<b>Application Ref:</b>	3/2026/0284	 Ribble Valley Borough Council <a href="http://www.ribblevalley.gov.uk">www.ribblevalley.gov.uk</a>	
<b>Date Inspected:</b>	N/A		
<b>Officer:</b>	BT		
<b>DELEGATED ITEM FILE REPORT:</b>		<b>Decision</b>	<b>PERMISSION NOT REQUIRED</b>

<b>Development Description:</b>	Prior notification for the erection of two agricultural buildings for the storage of machinery, equipment and agricultural materials.
<b>Site Address/Location:</b>	Lower Gazegill Farm, Cross Hill Lane, Rimington, BB7 4EE.

Drawing; Location

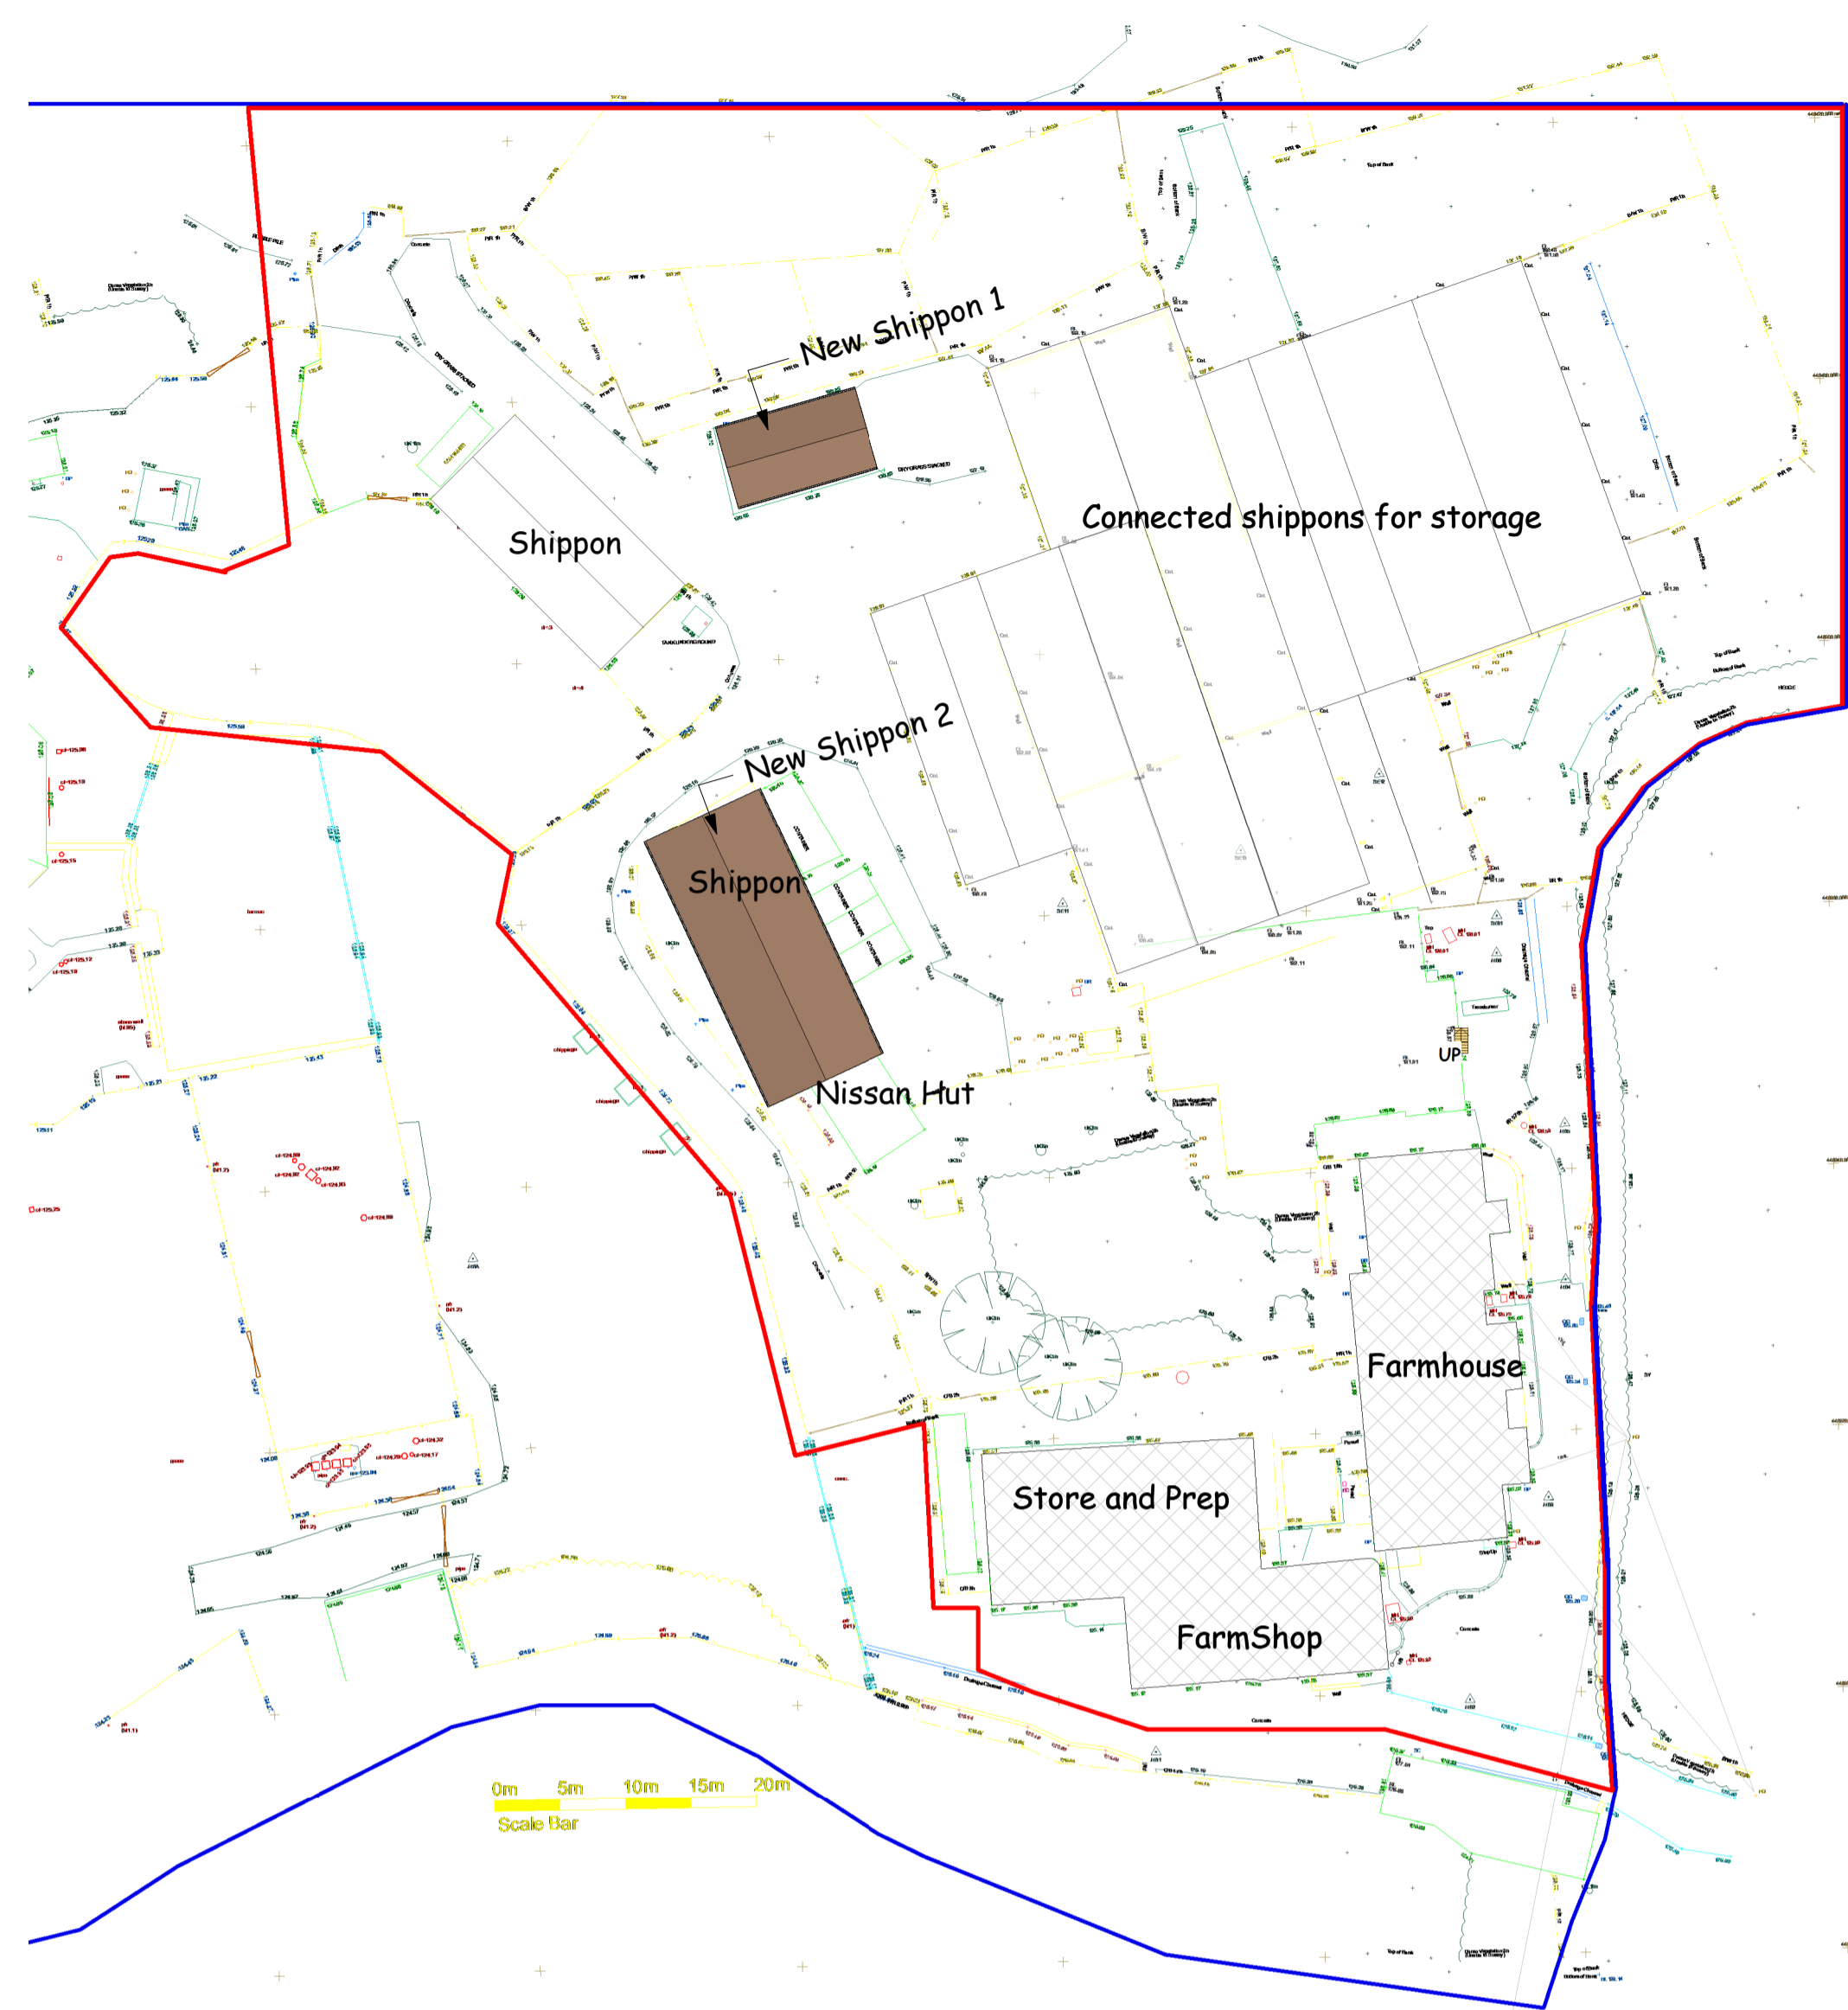
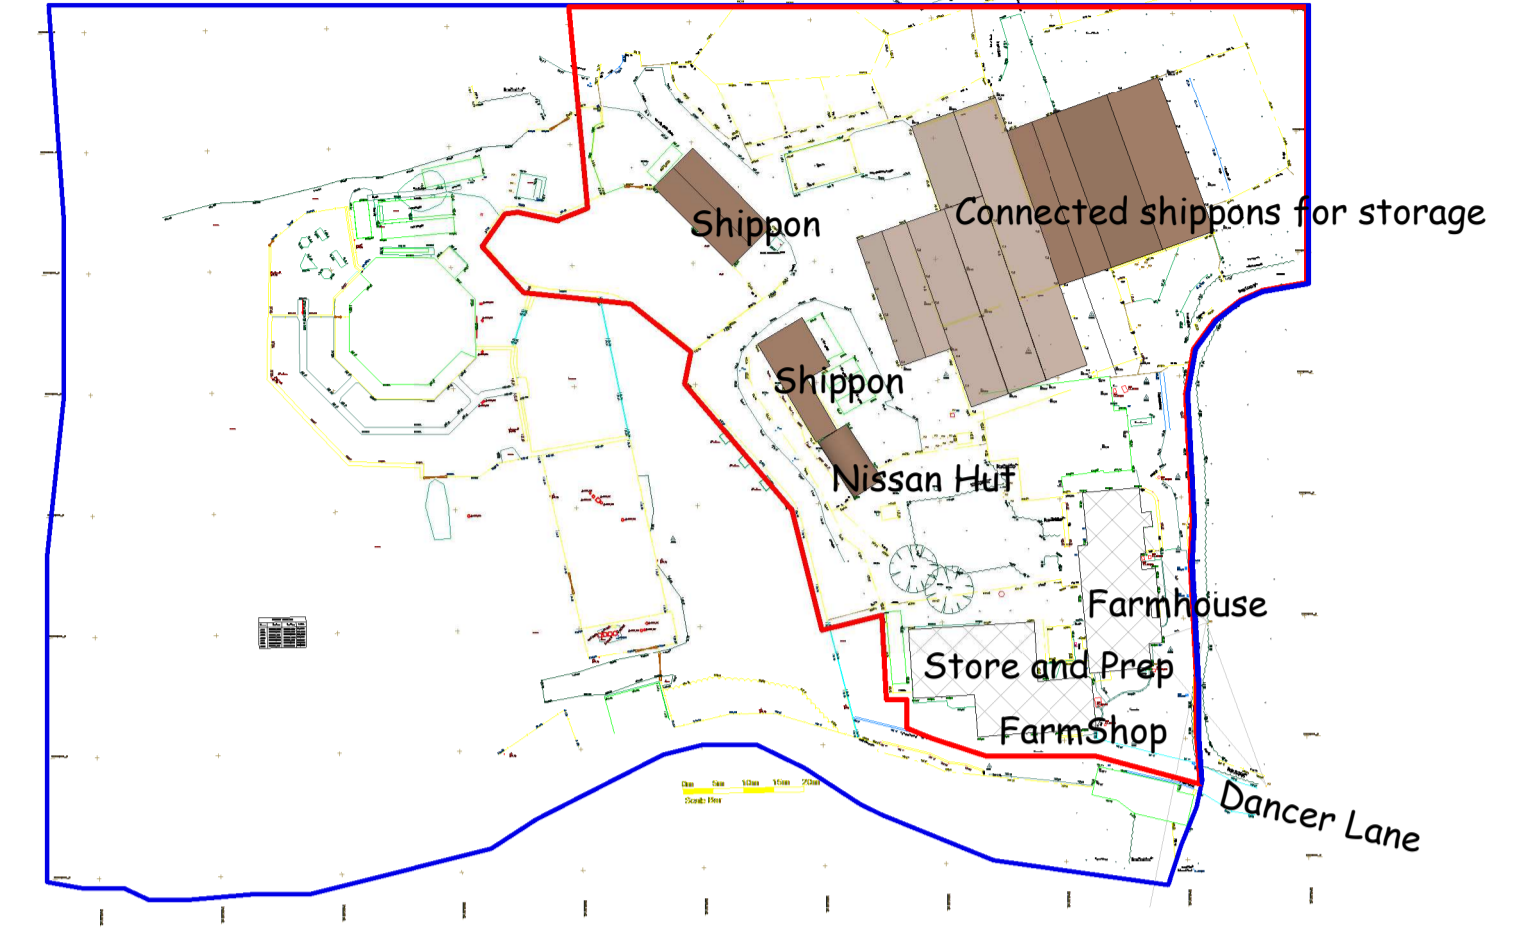
**The proposed agricultural buildings would be located approximately 730 metres away from the nearest trunk road or classified road which in this instance is the C582 Rimington Lane**

One of the proposed agricultural buildings would be sited on the footprint of existing agricultural buildings to be demolished and both agricultural buildings would be sited in close proximity to other agricultural buildings within the farmstead and as such would be read in concert with the site's existing built form. Consequently, the proposed buildings would share an acceptable relationship with the existing buildings on site and would not read as an isolated features within the surrounding landscape. The farmstead accommodates an existing agricultural operation therefore it is not considered that the proposed introduction of buildings to the site for storage would have any undue impact upon neighbouring amenity.

Drawing; Shippon 1

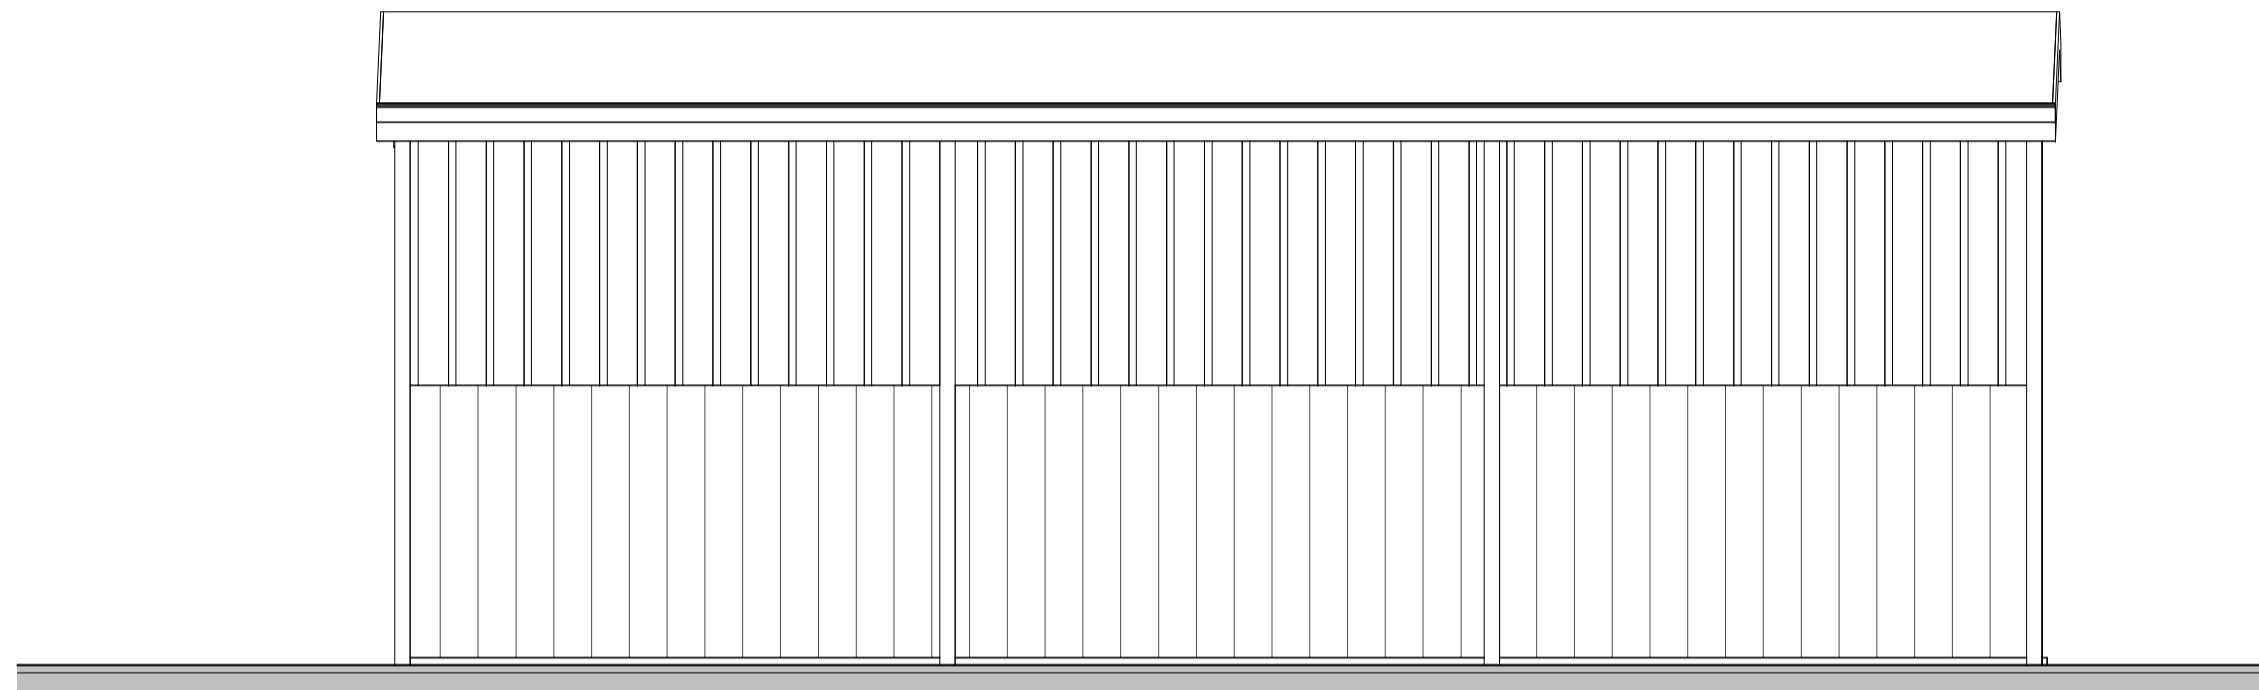
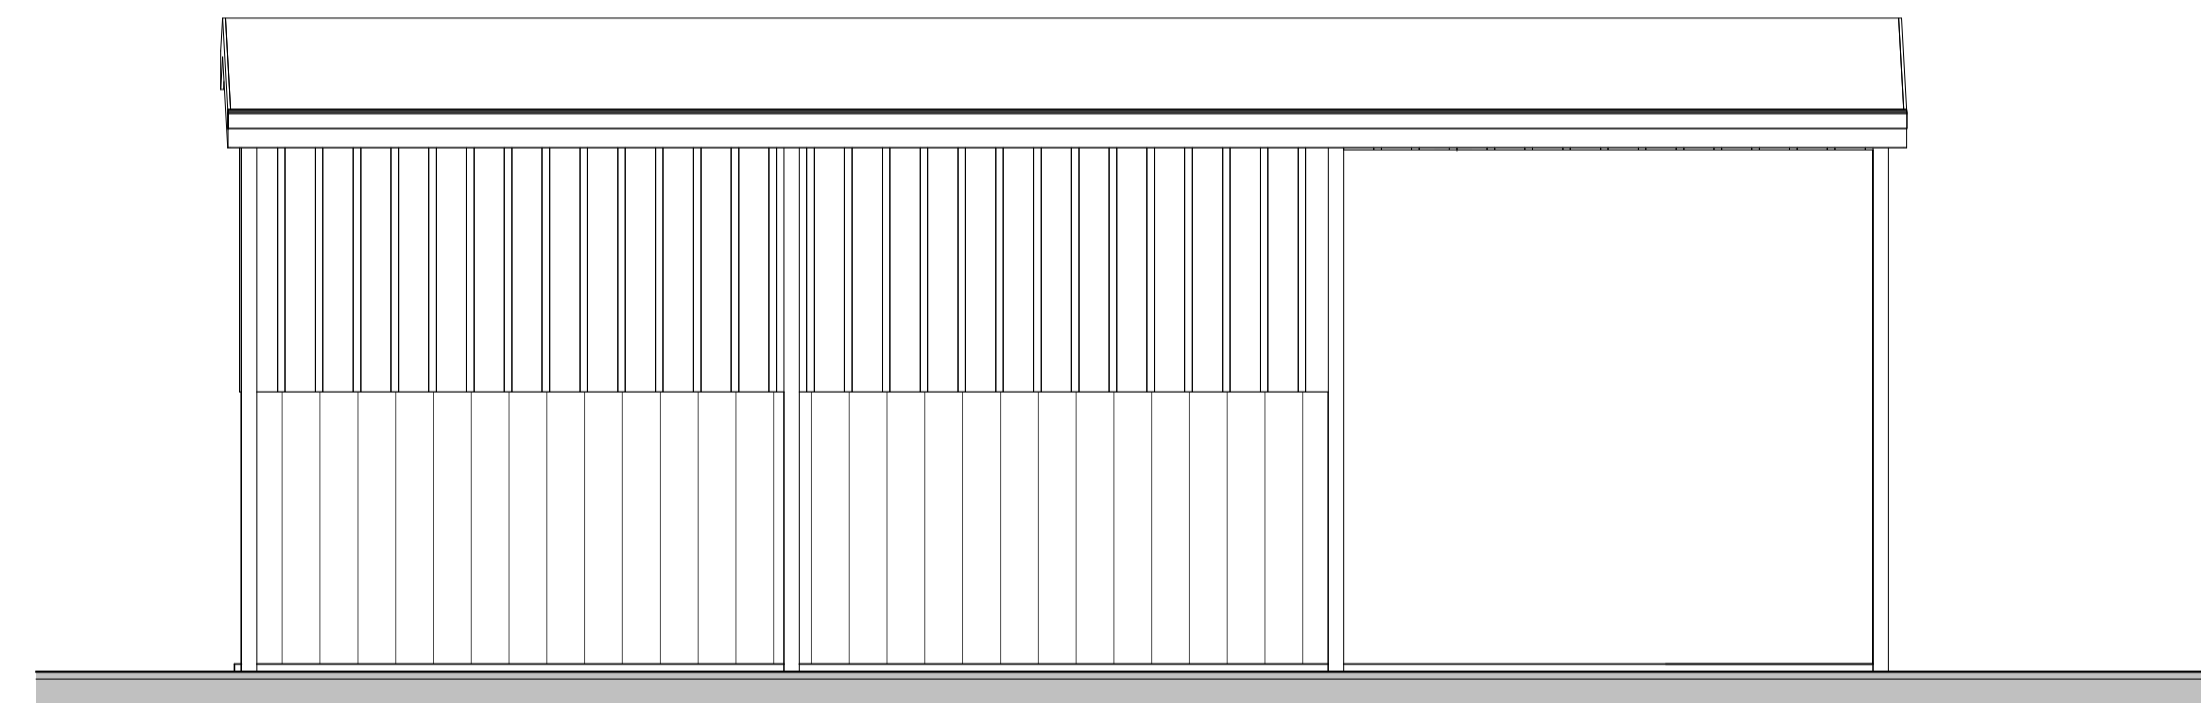
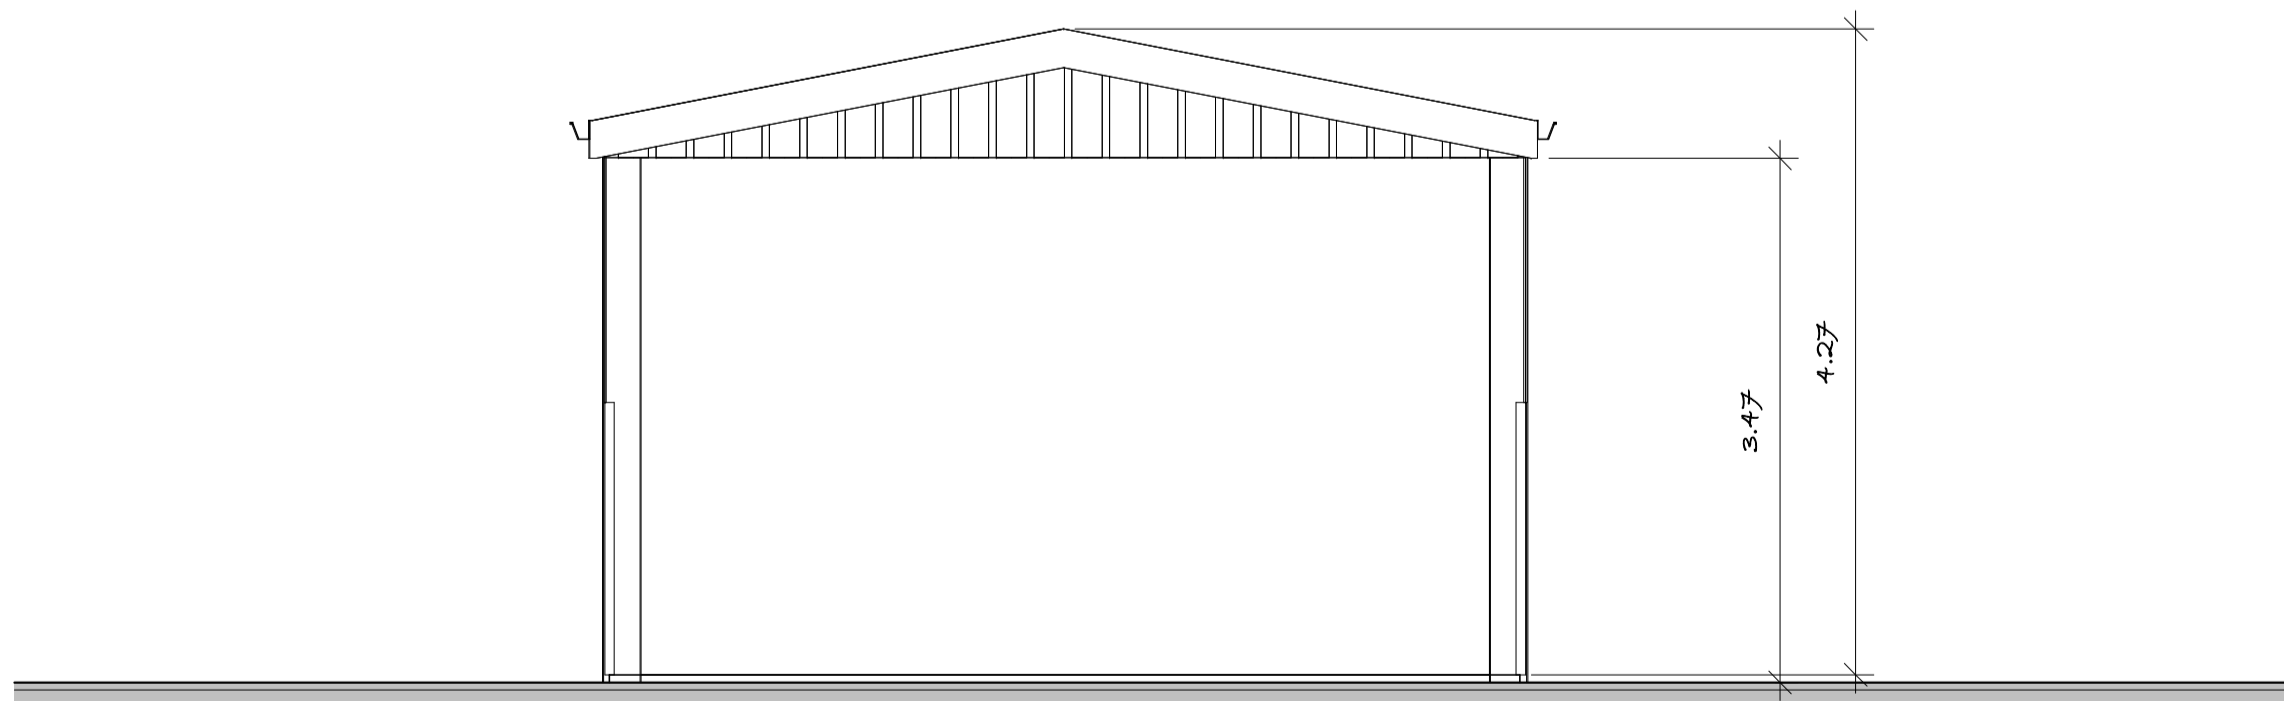
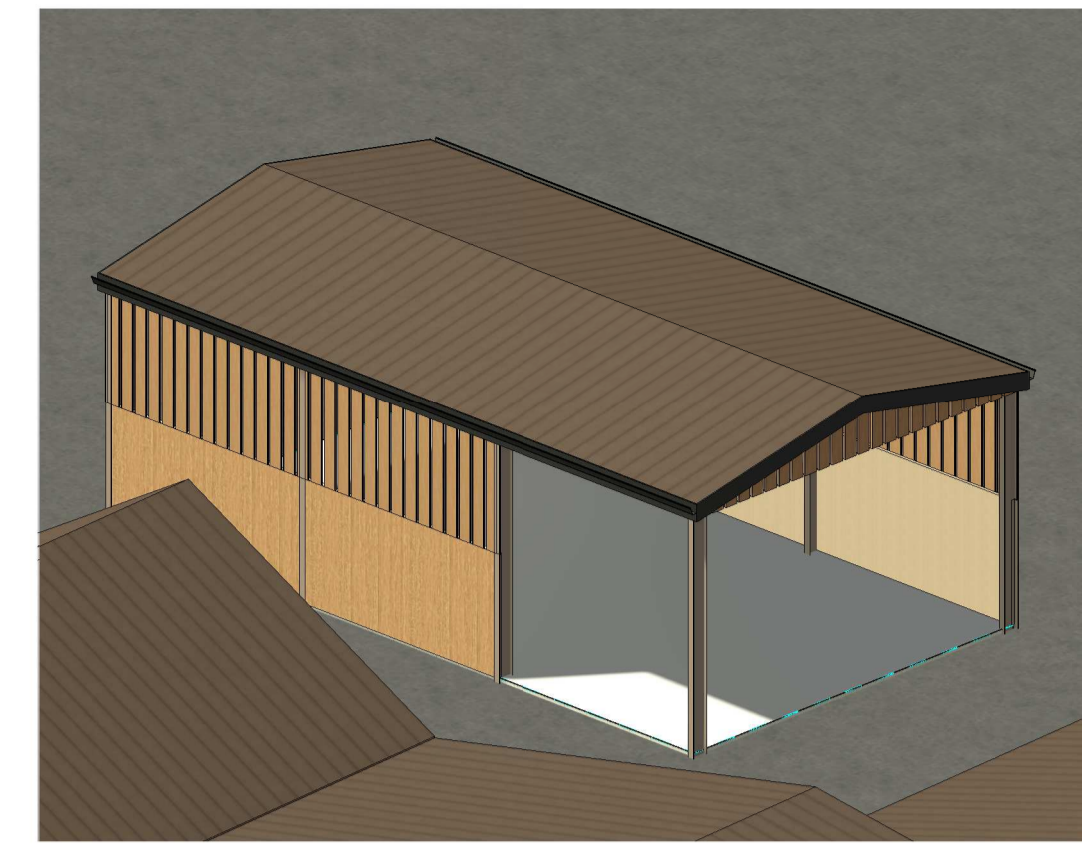
**The highest part of the proposed agricultural buildings would be 4.2 and 4.7 metres**

The proposed agricultural buildings would comprise a portal framed design detailed in timber cladding and dark green profiled roof sheets, all of which are materials commonly used in the construction of modern agricultural buildings and which would also match the external appearance of the existing buildings within the farmstead. As such, the external appearance of the buildings would be in keeping with the existing built form within the application site and rural vernacular of agricultural buildings within the locality. In addition, the proposed buildings would comprise a similar size to the existing shippon buildings within the farmstead with respect to their footprint and would therefore not read as an over dominant additions to the application site. Accordingly, it is not considered that the proposed development would be harmful to the visual amenities of the immediate area or wider landscape.
